**Consultation Response from Mark Berry KC,
Highways Development Management**

2022/93679 Field House, 15 Wellington Street, Dewsbury, WF13 1BQ

Discharge condition 10 (CMP) on previous permission 2019/92962 for erection of additional storey and conversion of building to provide 23 self-contained apartments and A3 use in basement and part of ground floor (Listed Building within a Conservation Area)

Logistics Plan:

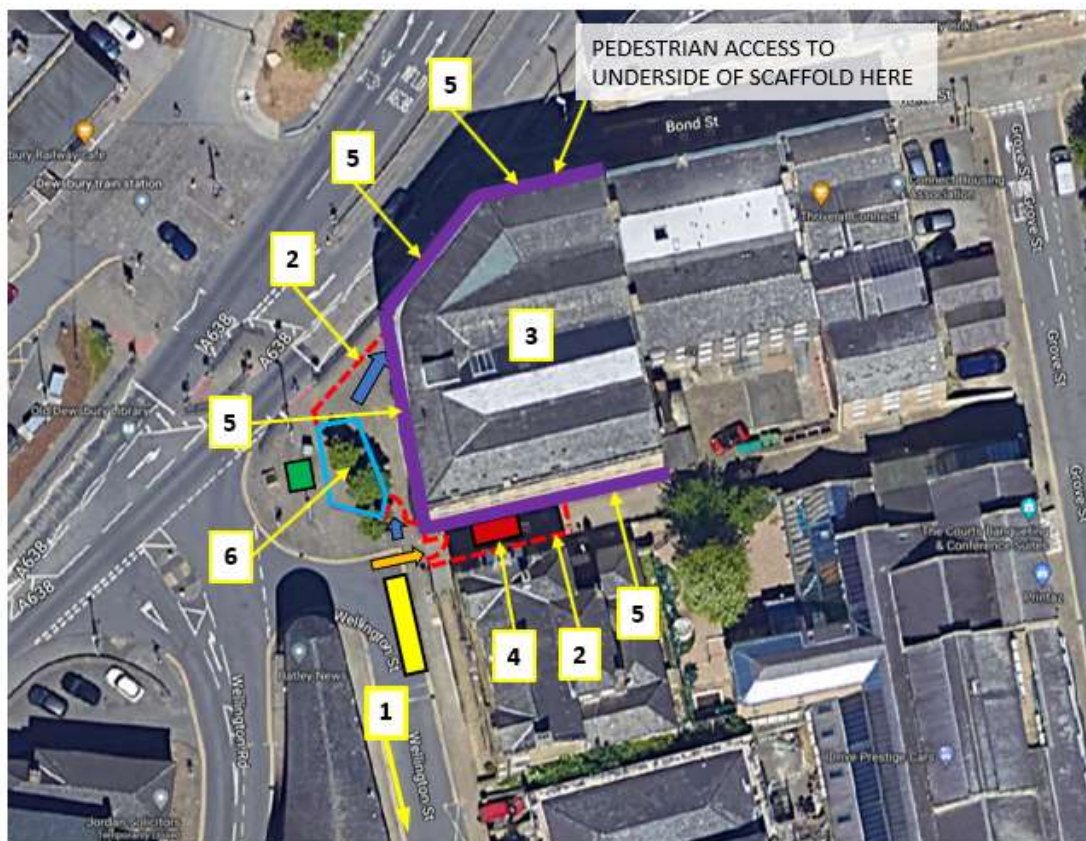
Can the applicants confirm the residual width of footway that will be available to pedestrian around the perimeter of the site when fencing and scaffolding are erected, and the works are ongoing.

The applicants have confirmed that pre-development road condition surveys will be provided prior to commencement of the works, the logistics plan attached to the Construction Management Plan shows the footway provisions around the works.
